FIVE ESTUARIES OFFSHORE WIND FARM

**Appendix J4 to the Natural England Deadline 4 Submission  
Natural England's Comments on the Applicant's Change Request Documents [AS-  
040, AS-048, AS-054, and AS-057]**

Planning Inspectorate Reference EN010115

03 December 2024

SCALE: 1:25,000 PLOT SIZE: A3 DATUM: OSGB 1936 PROJECTION: British National Grid

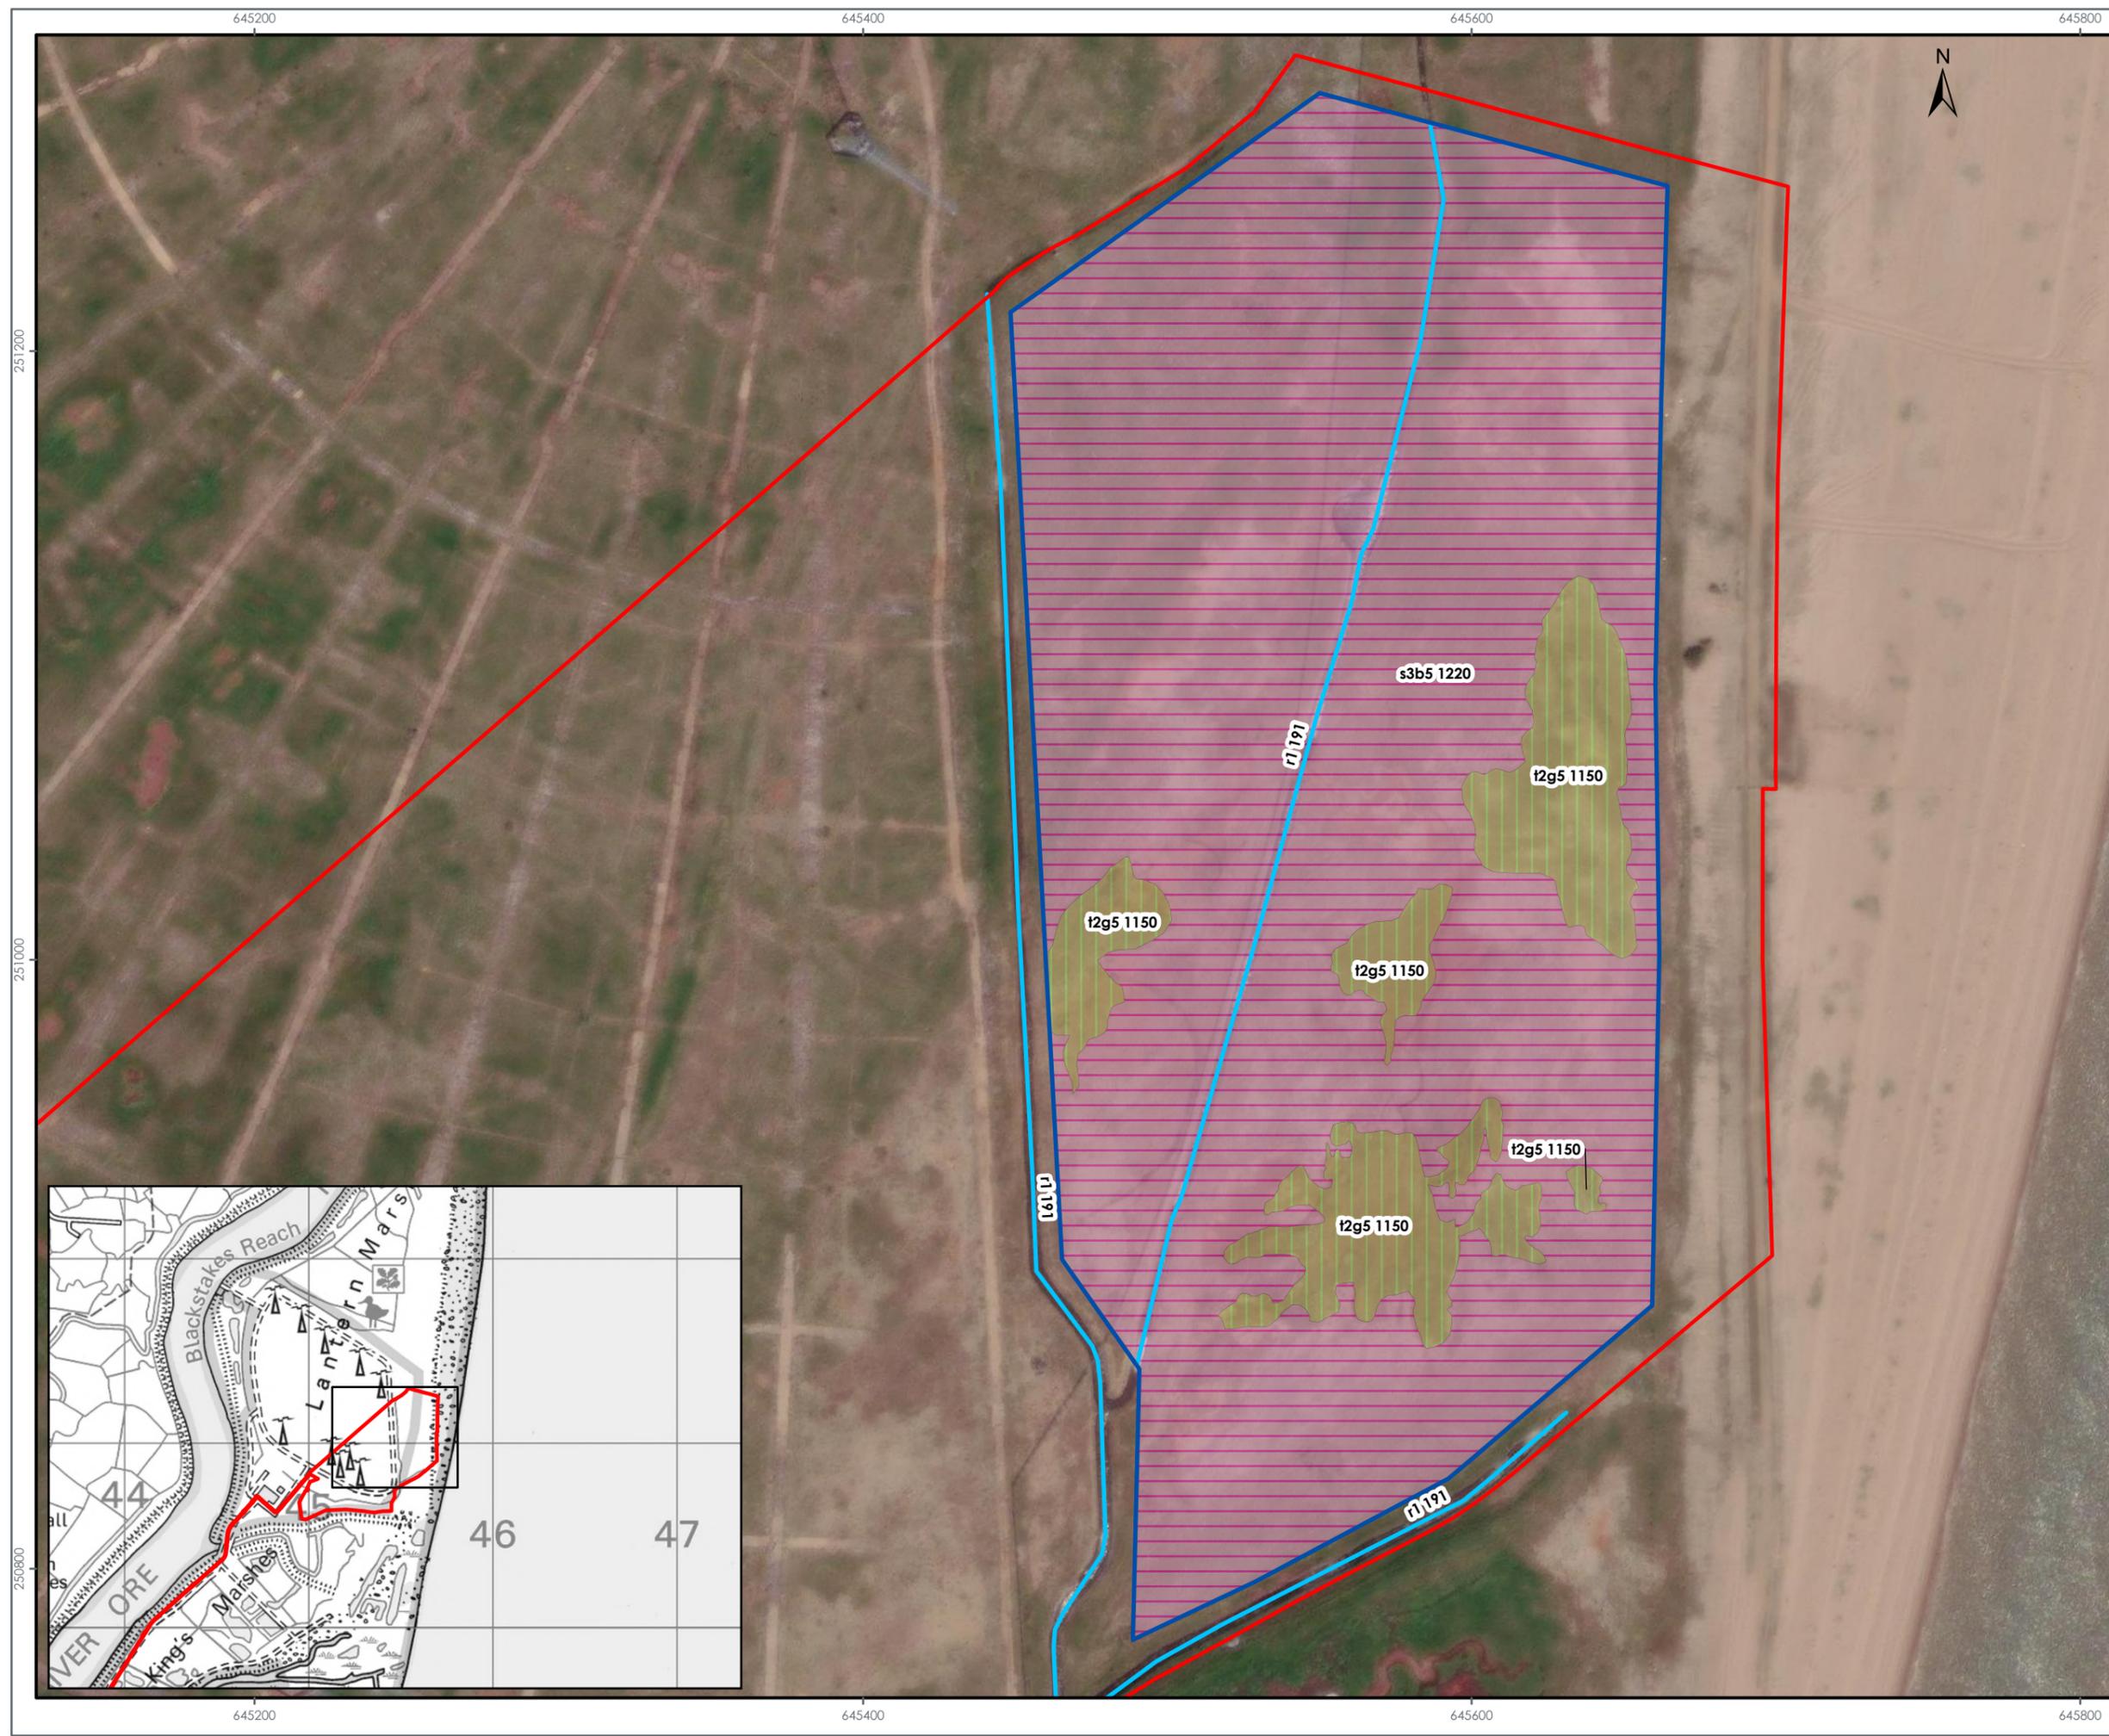
Natural England notes that the map on page 66 shows that more than a third of the current proposed compensation site sits outside of the original survey area. Consequently, without baseline information we are unable to adequately assess the ecological impacts. Furthermore, our earlier comments may need to be revisited, along with those issues previously considered resolved, when the necessary additional information is available.
